26th November 2020

Application No: CM/46/20/HH
Site Address: Mistletoe Farm Horsemere Green Lane Climping BN17 5QZ
Description of works: Construction of a 3 x bay carport with habitable roofspace

OWQC31679

BLOCK PLAN 1/500

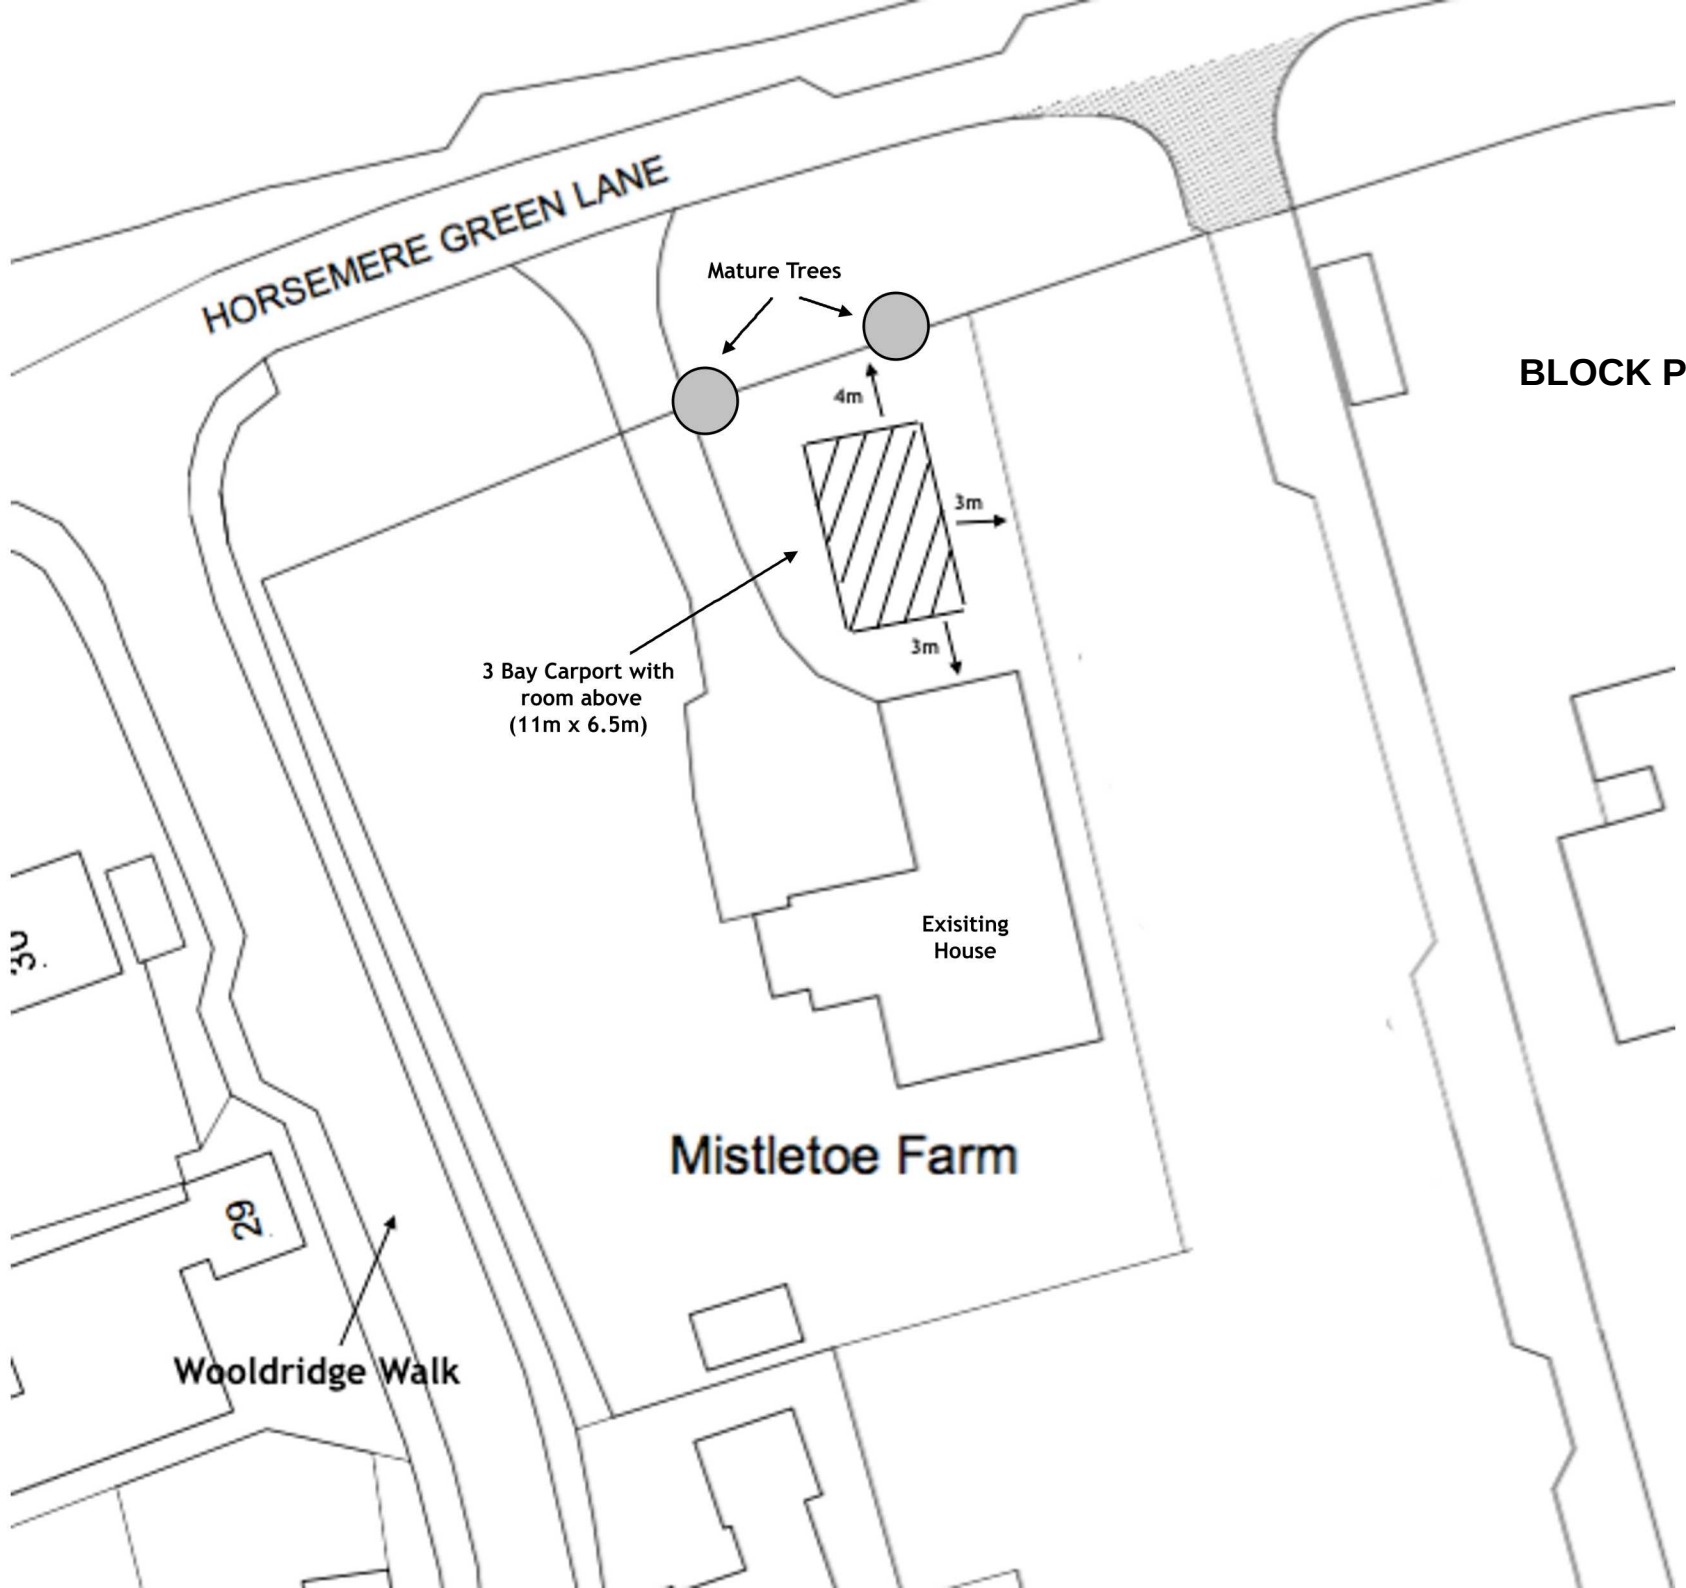
Objection Council is concerned by the size, and the positioning of the proposed car port and habitable roof space as it is in front of the building line of the existing dwelling and of the neighbouring property (the new dwellings approved under planning application CM/37/18/OUT). In addition Council feels there is a lack of information about the proposed habitable space (including usage and connection to services)
